**Town & Country Planning Act 1990 (as amended)
Town and Country Planning (Development Management Procedure) (England) Order 2015
Application for Planning Permission**

Development Retention of 5 No. temporary storage containers for ancillary storage. This application affects the setting of listed buildings.

Location Clymping Mill Clymping Street Clymping

Site Plan: 1:500@A3

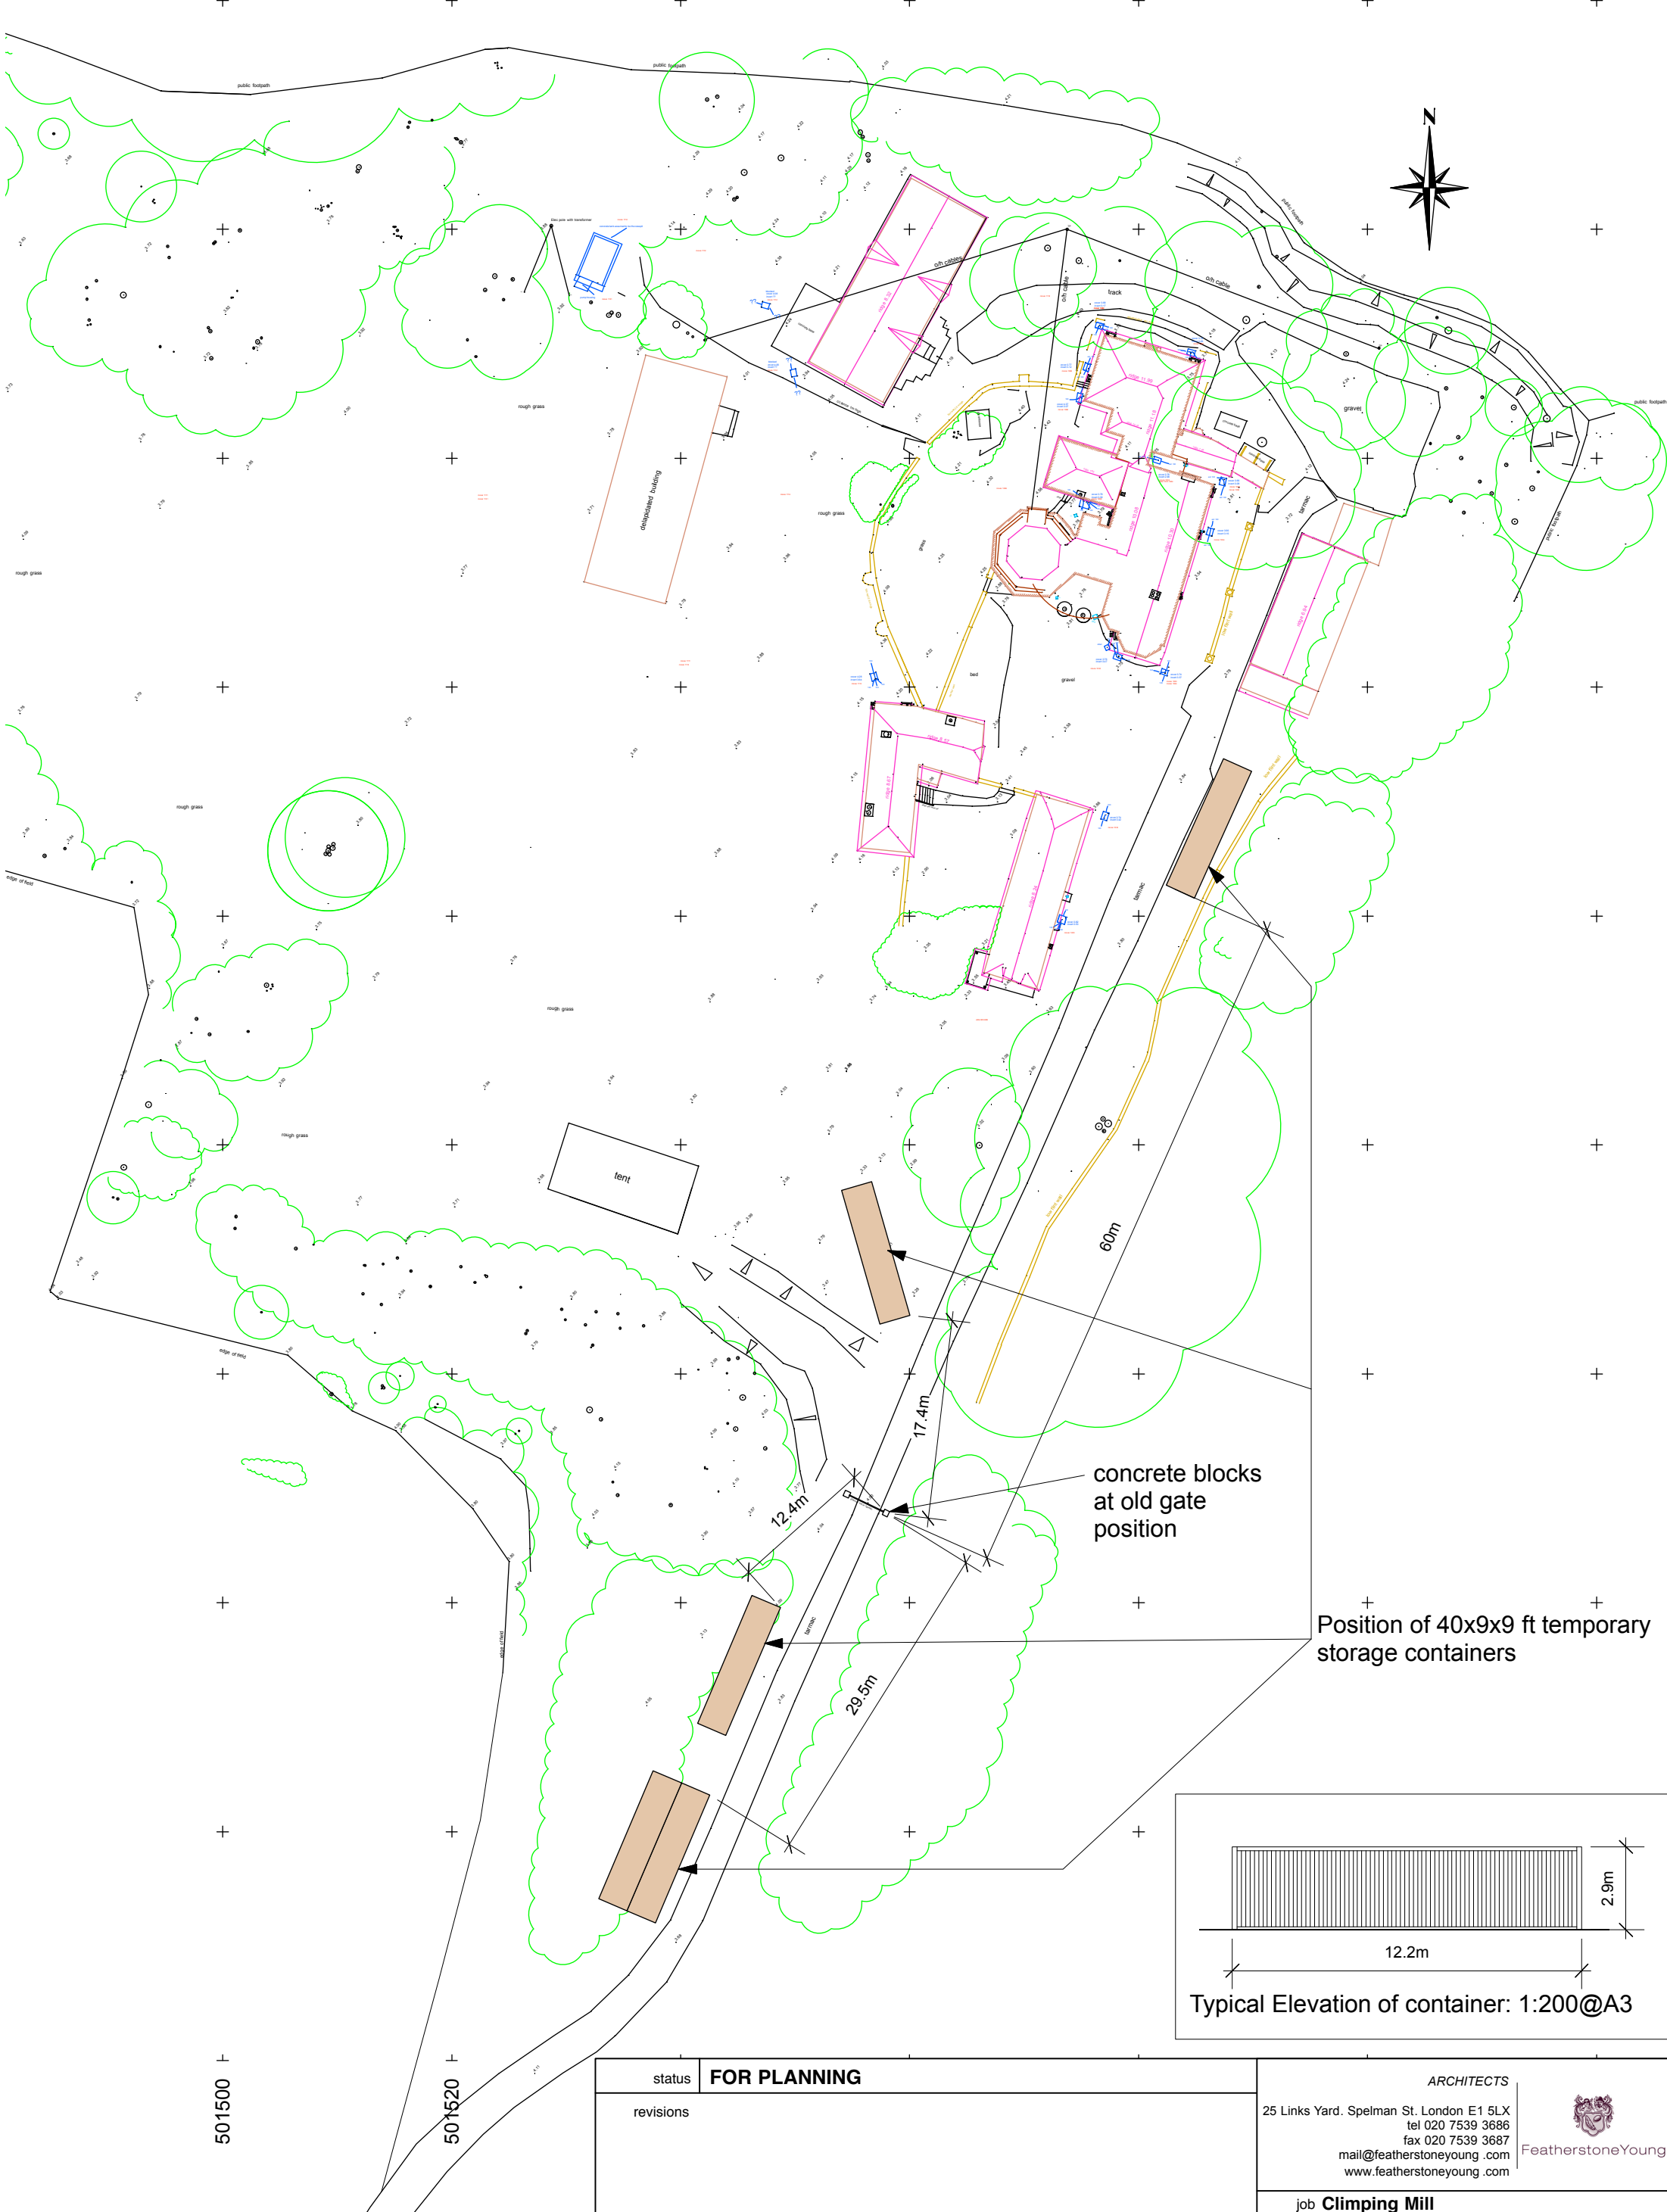
On the block plan, please show more of the site, to the south, to include the southern most boundary of the site to match the southern end on the location plan.

Location Plan: 1:2500@A3

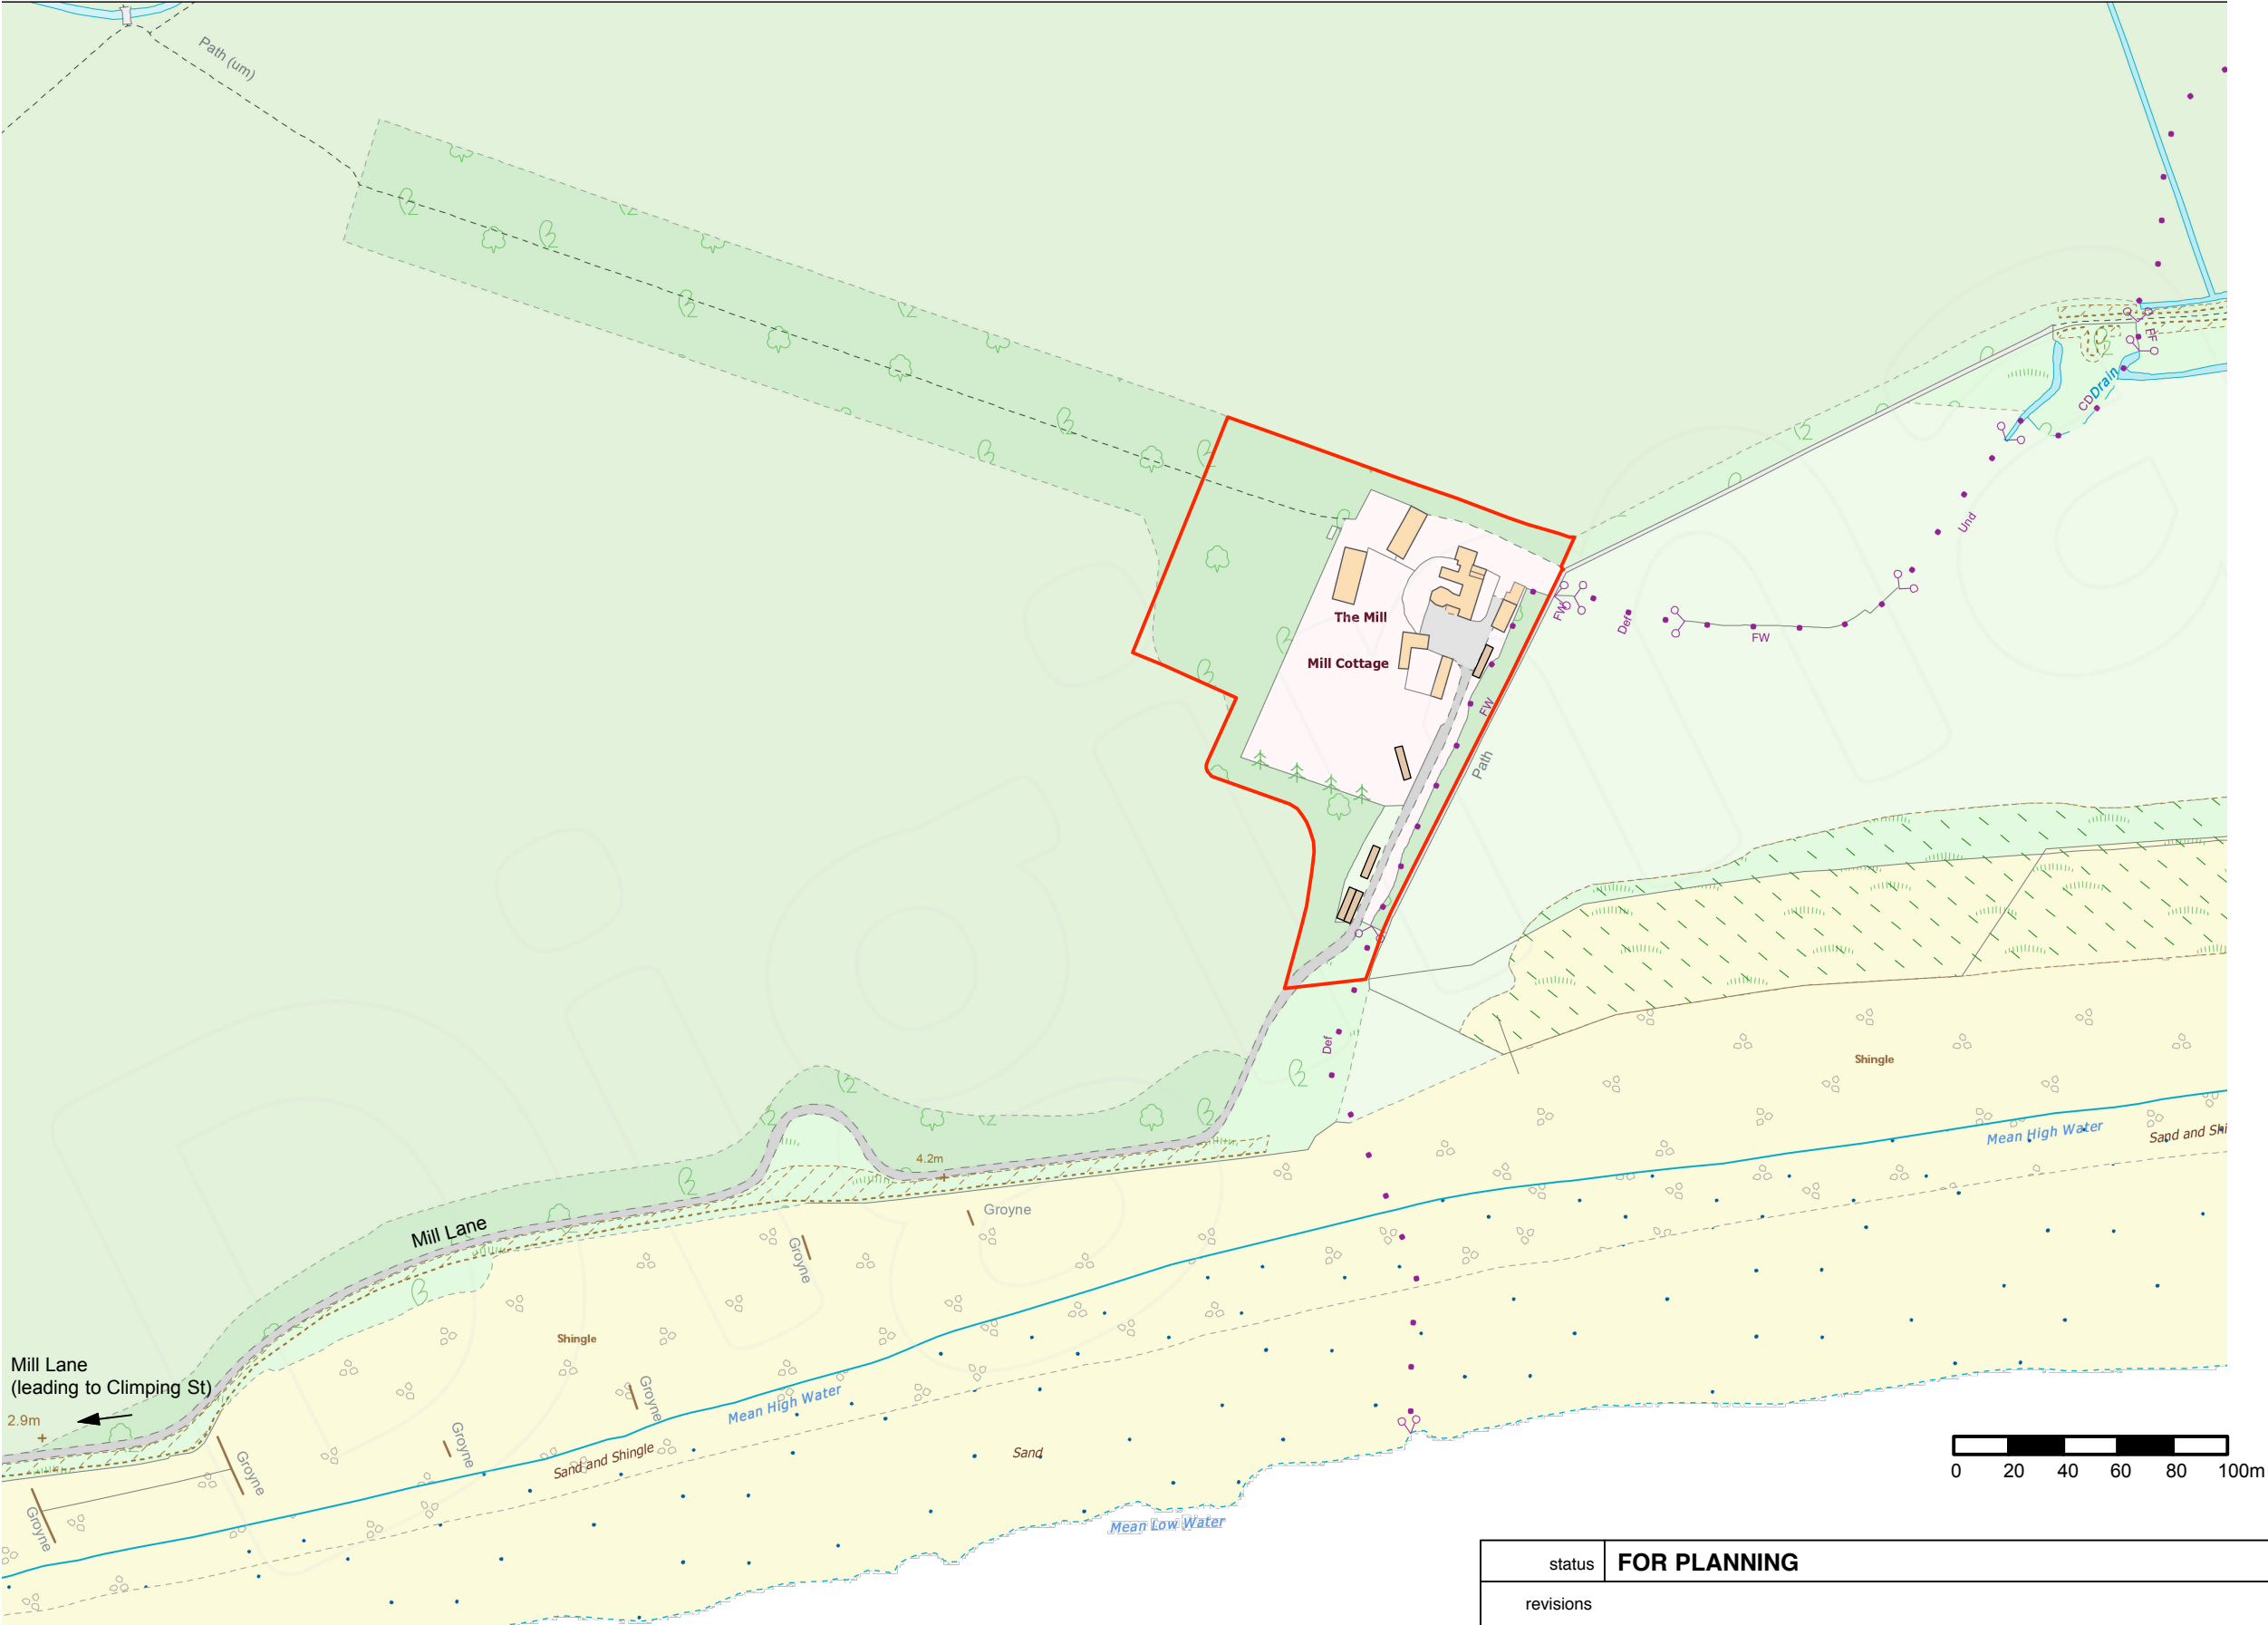
On the location plan, please show, to scale, in metres, the position of the 5 No. storage containers.
